INDEPENDENT EXPERT REVIEW

WHITE ROCK WIND FARM PROPOSAL

*Prepared for
NSW DEPARTMENT OF PLANNING
& ENVIRONMENT*

17th July 2019
REF: 990-Z1-01
REVISION: D

Figure 4 -
WRWF Project Approval and
Stage 2 (130 m hub and 70 m blade)
wind turbine comparison

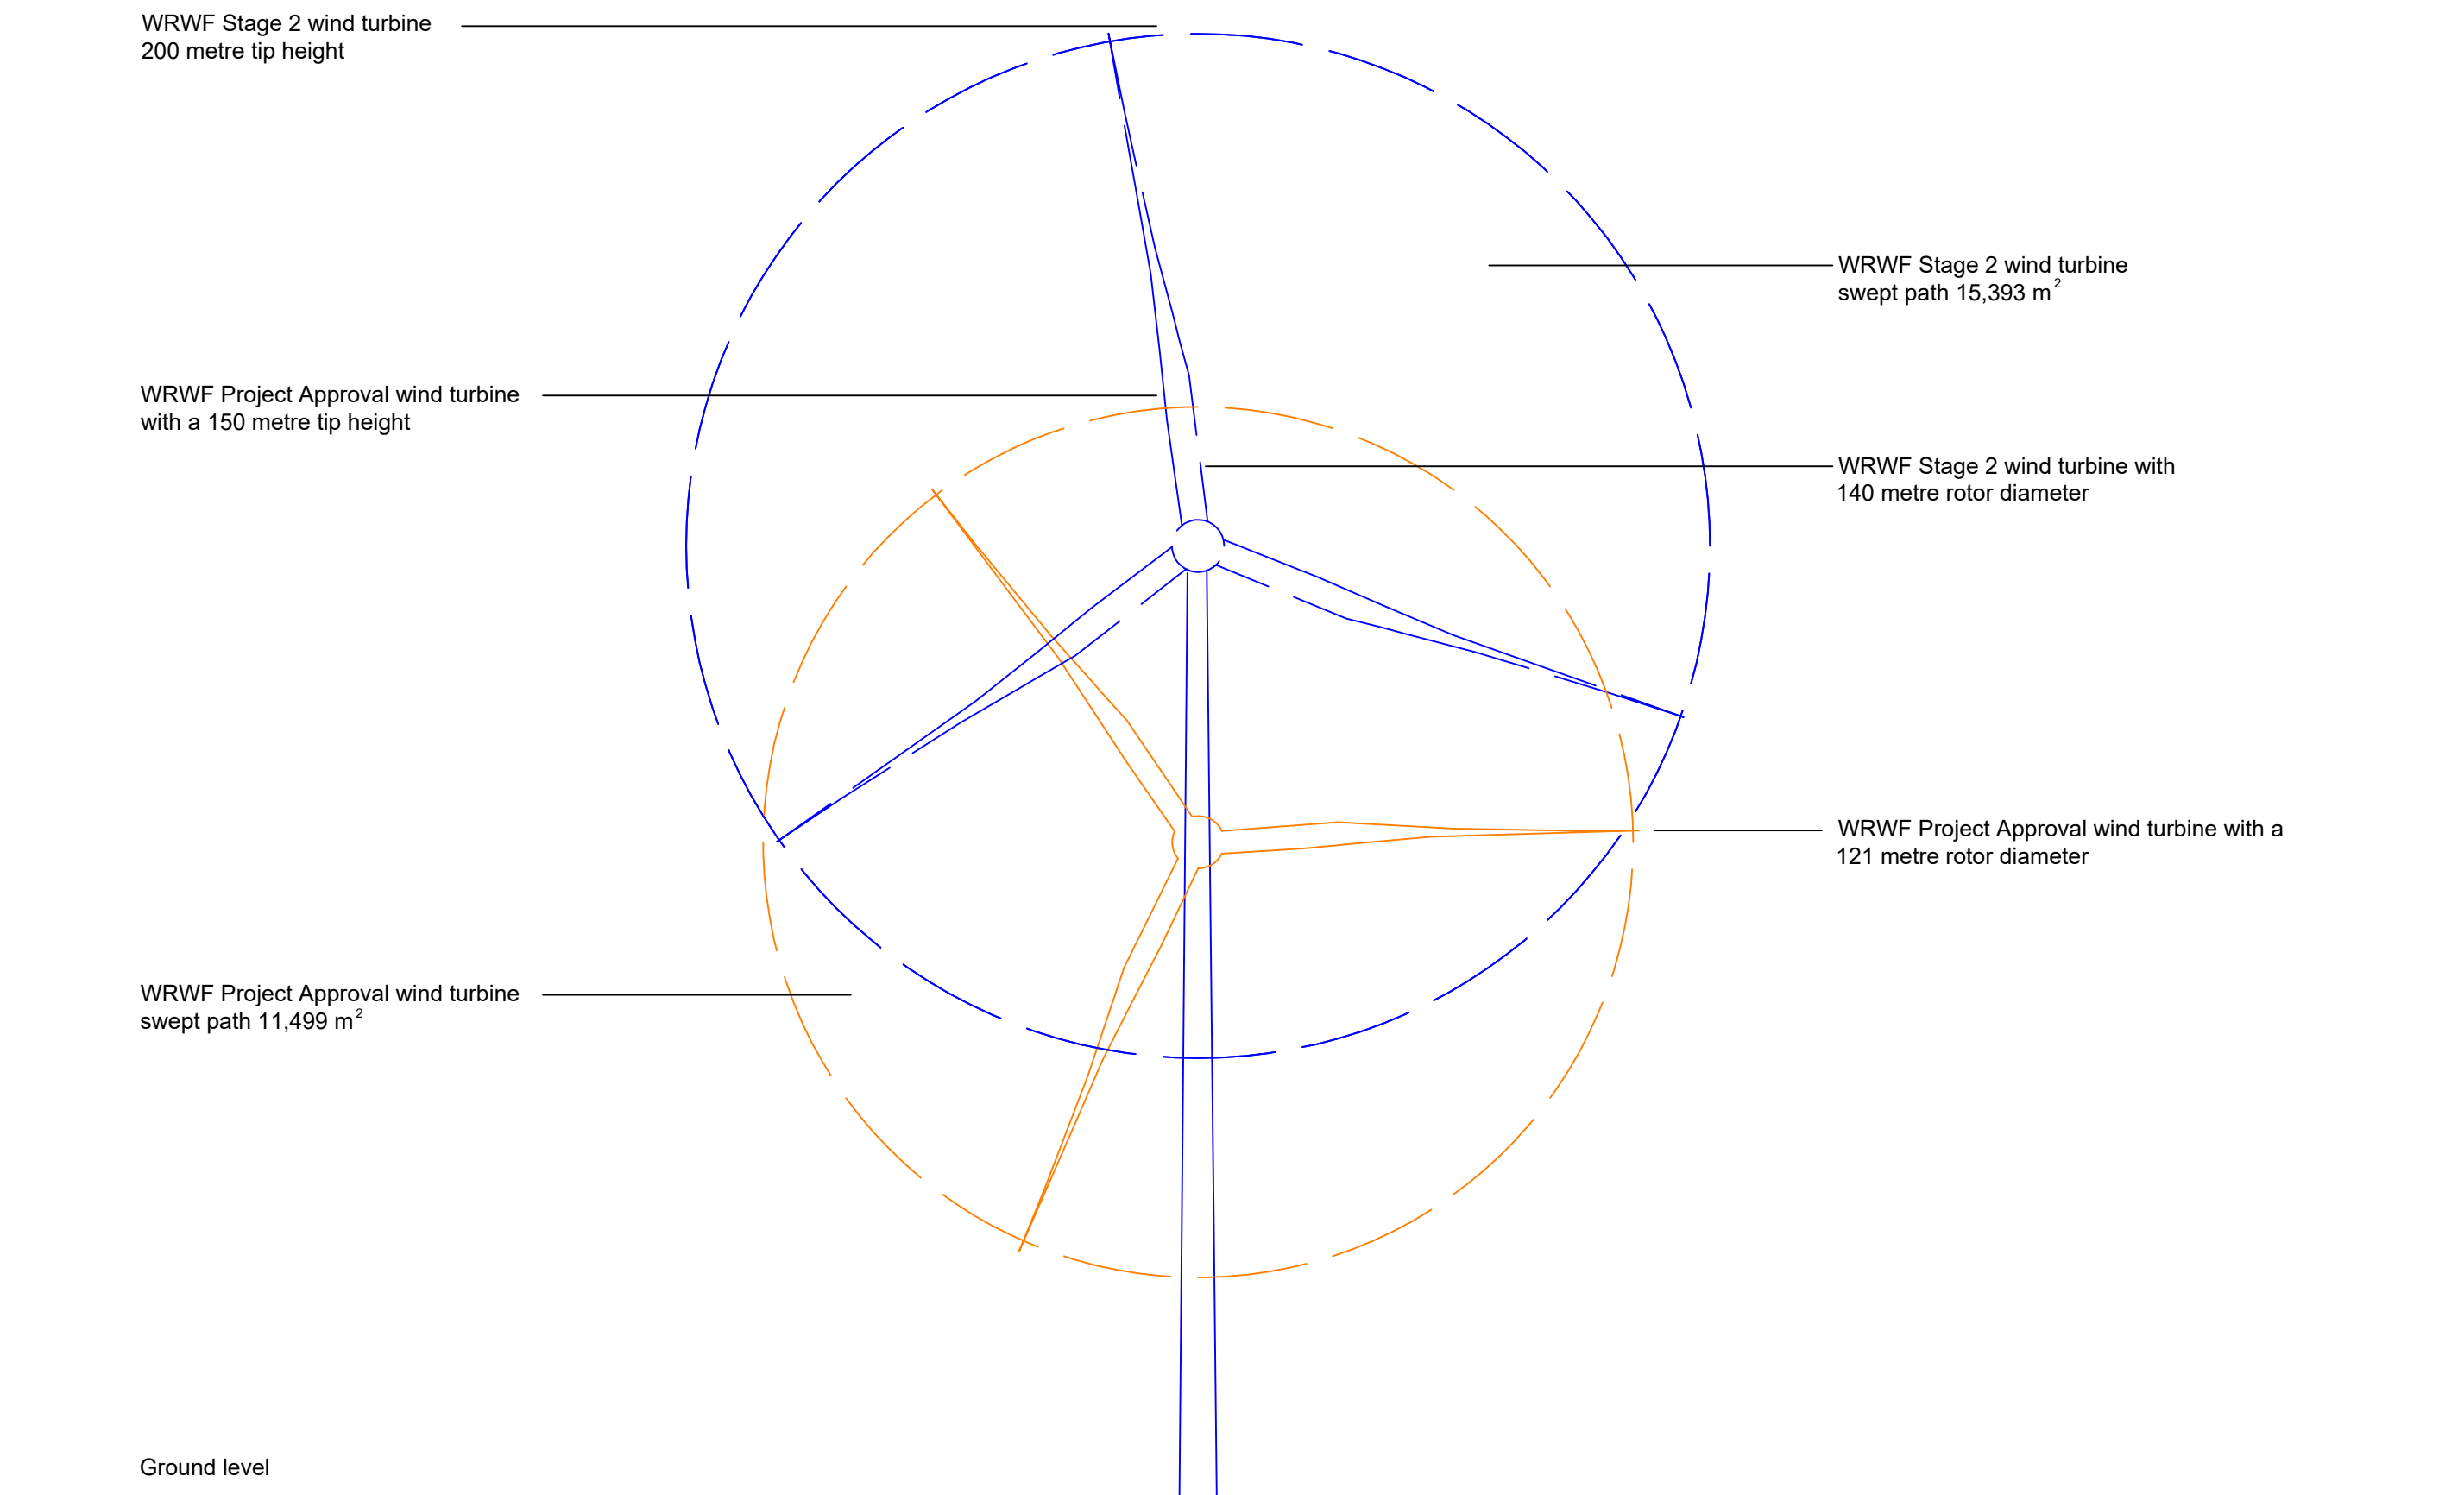
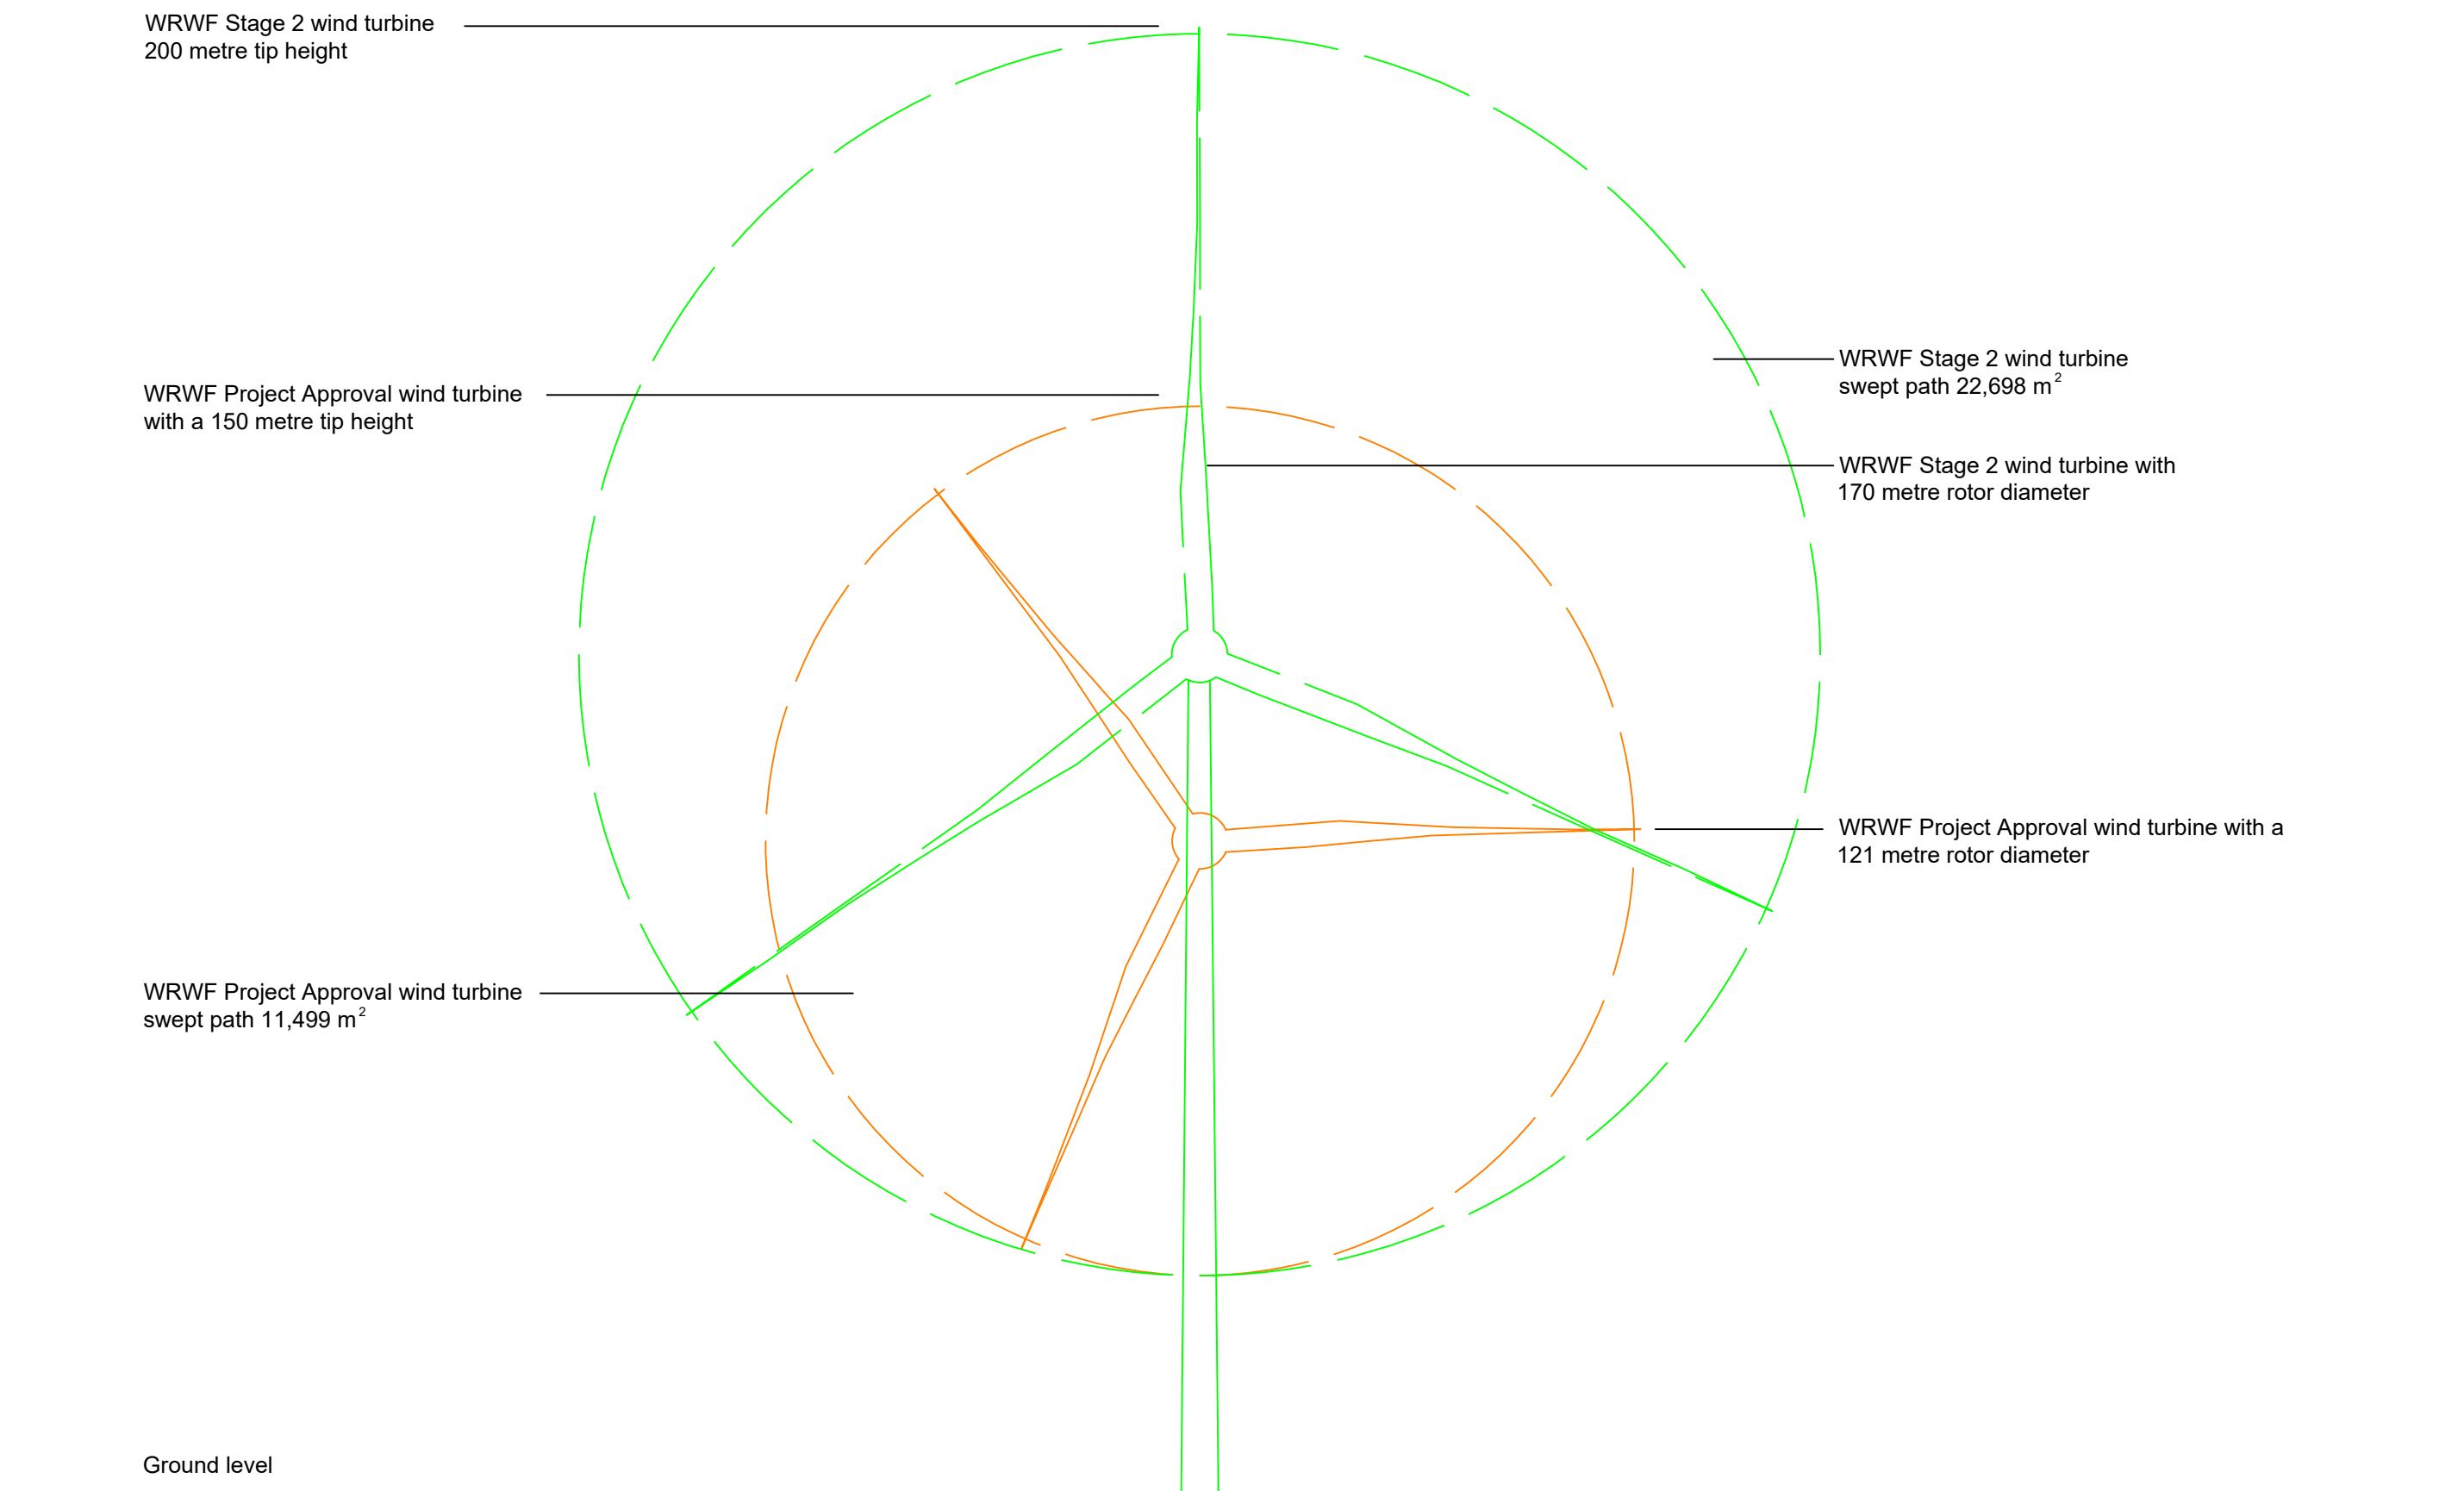
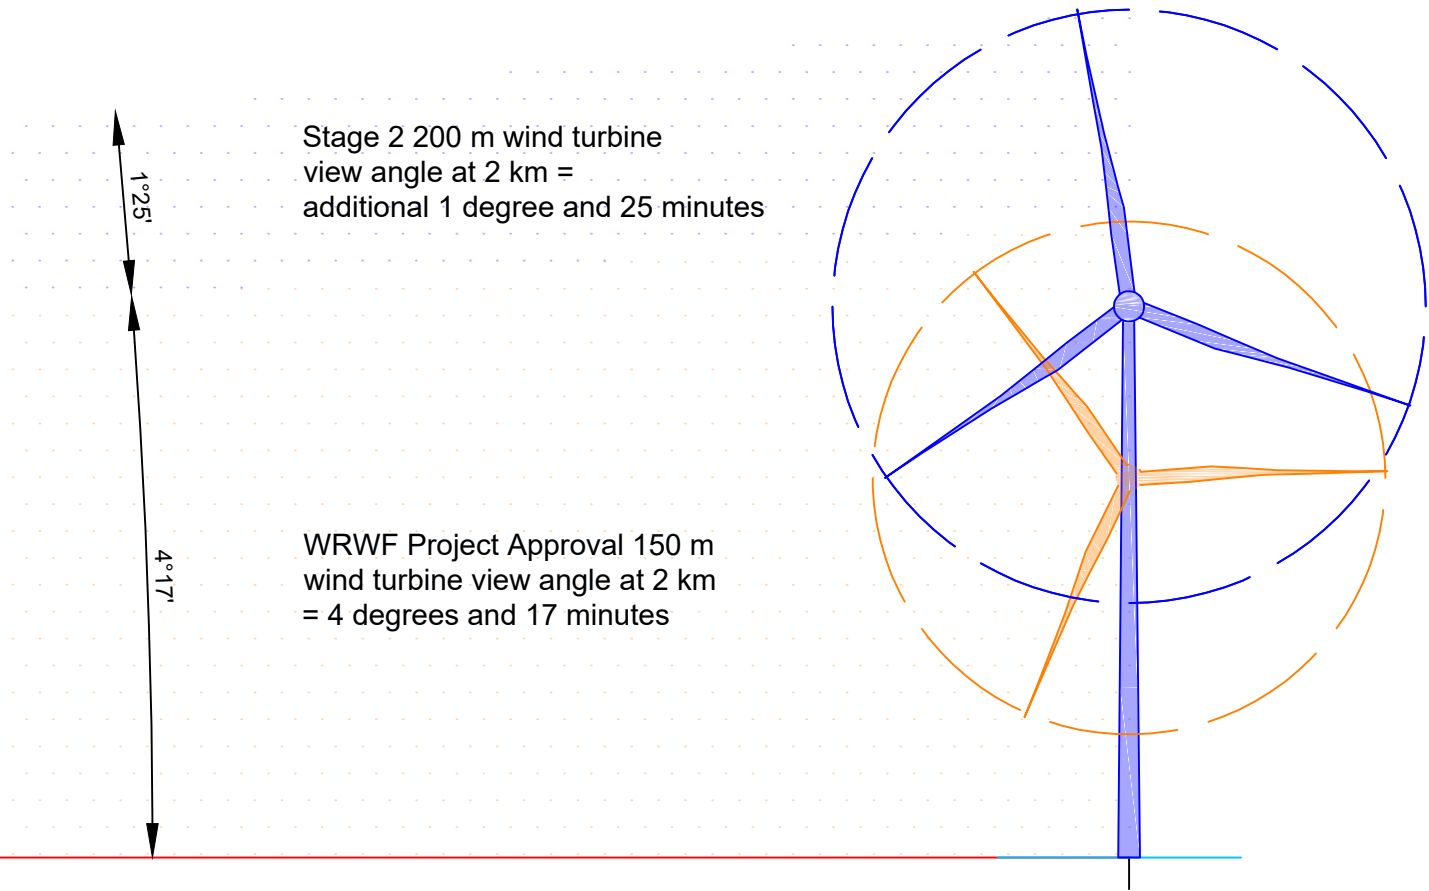
In section 4 of the LVIA a list of the numerical differences between the the 2012 Approval and Mod 6 turbine layout and characteristics is provided. A conclusion is then reached in section 4.4 that "*views toward additional wind turbine rotors and blade tips are not considered to result in a magnitude of visual effect which is greater than the magnitude of the visual effect associated with the WRWF Project Approval.*" This conclusion does not appear to have any analytical basis related to each individual residence or impact other than an intuitive balancing by the assessor of the numerical changes.

In our opinion, this methodology results in several steps of the visual assessment process outlined in the VAB not being properly considered. This includes use the multiple wind turbine tool, the preparation of a visual baseline study, identification of a scenic quality class and most critically; a performance evaluation based on the objectives for each zone/viewer level set out in the VAB.
